Re: Gilliam's Irish Pub & Restaurant, LLC
1165 Cumberland St.
Dunn, NC 28334

The application for your proposed food service establishment has been reviewed but not approved due to the lack of information. The plan review cannot continue until the following information is provided.

○ PROPOSED FLOOR PLAN
 SCALE: 1:25

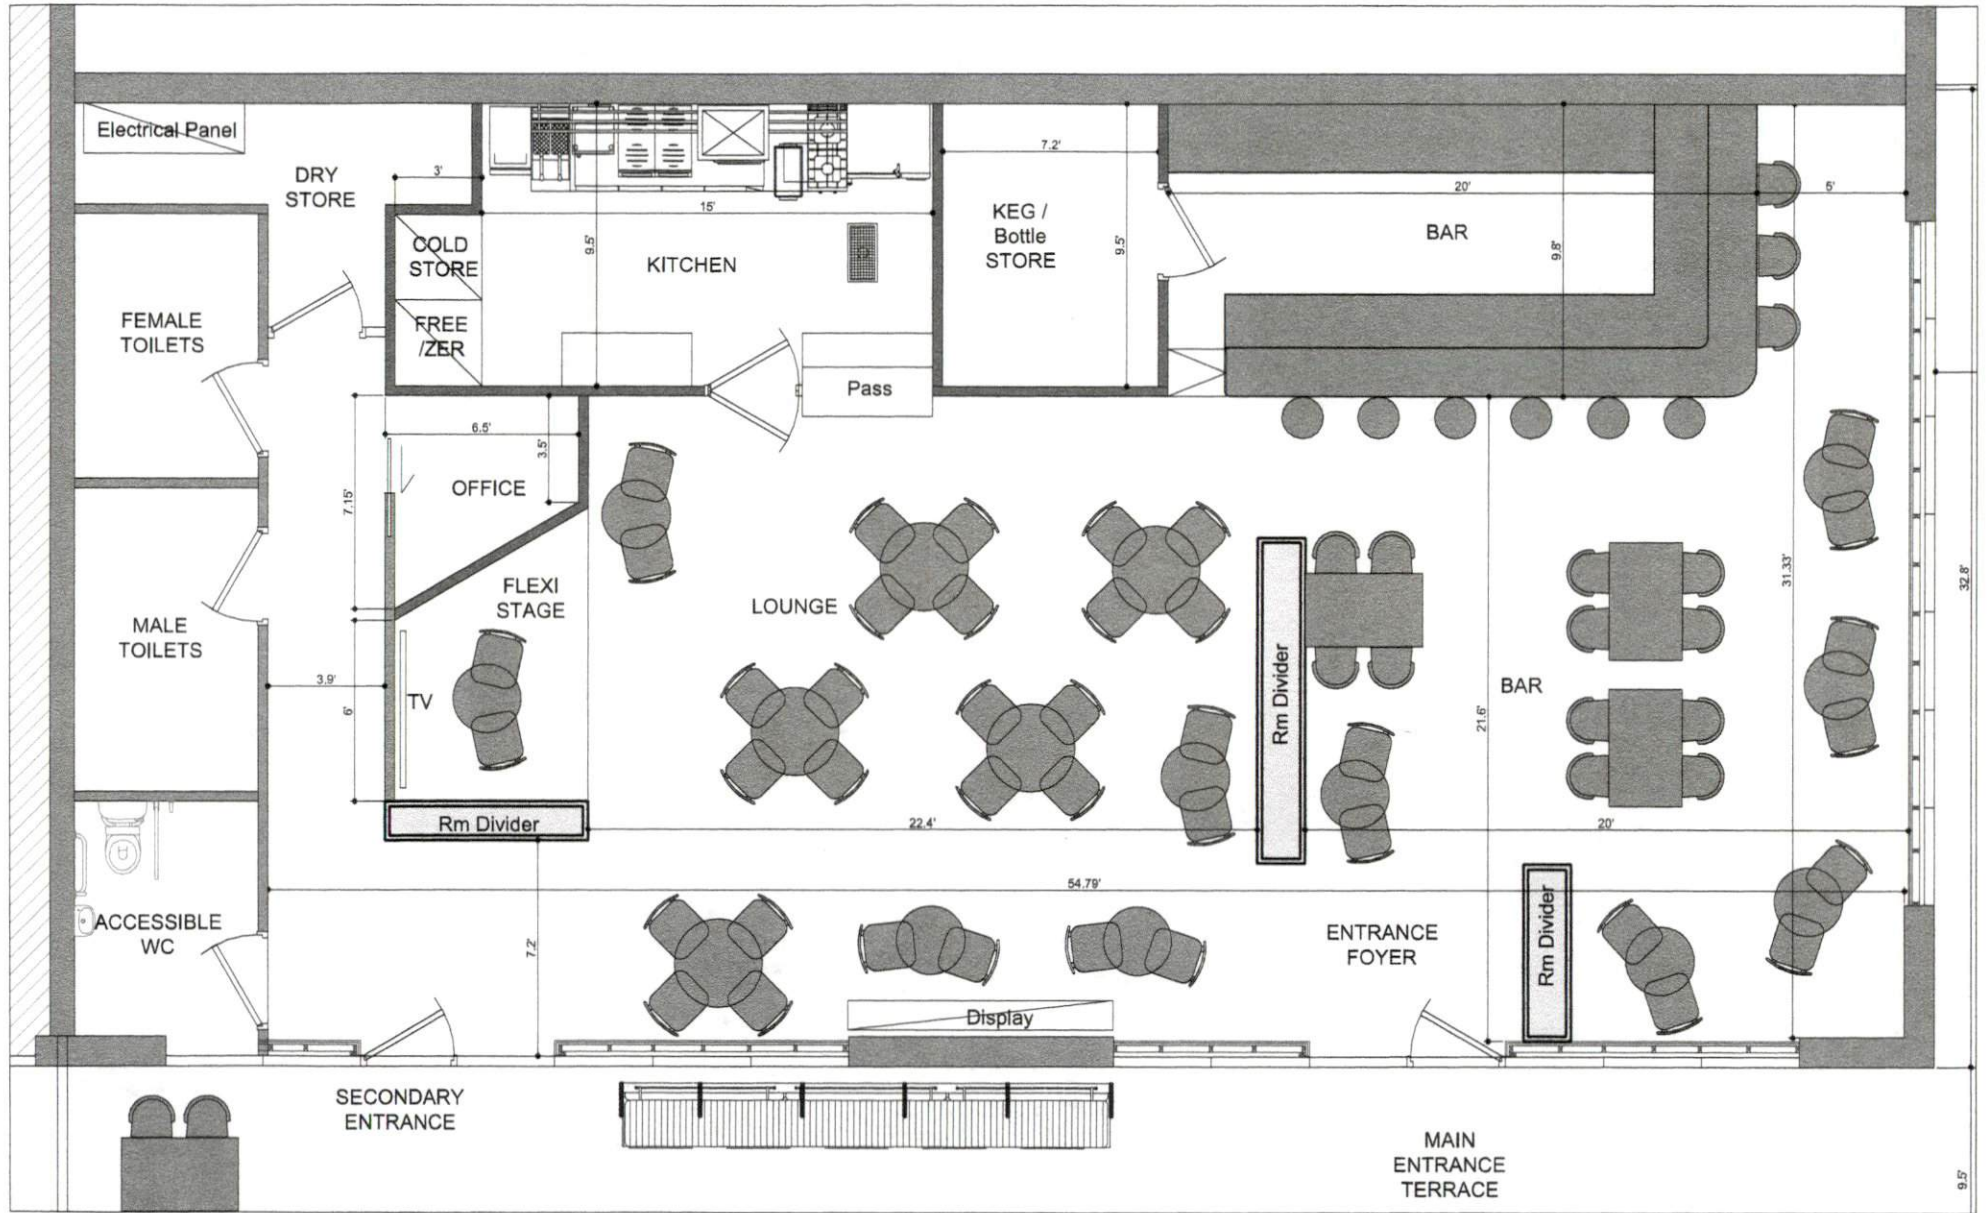
1. A complete menu.
2. The floor plan you provided is not drawn to a recognizable scale
3. The equipment specifications were not provided for the equipment.
4. All proposed equipment must be indicated on site plan including counter-top equipment and labeled or referenced to an equipment list.
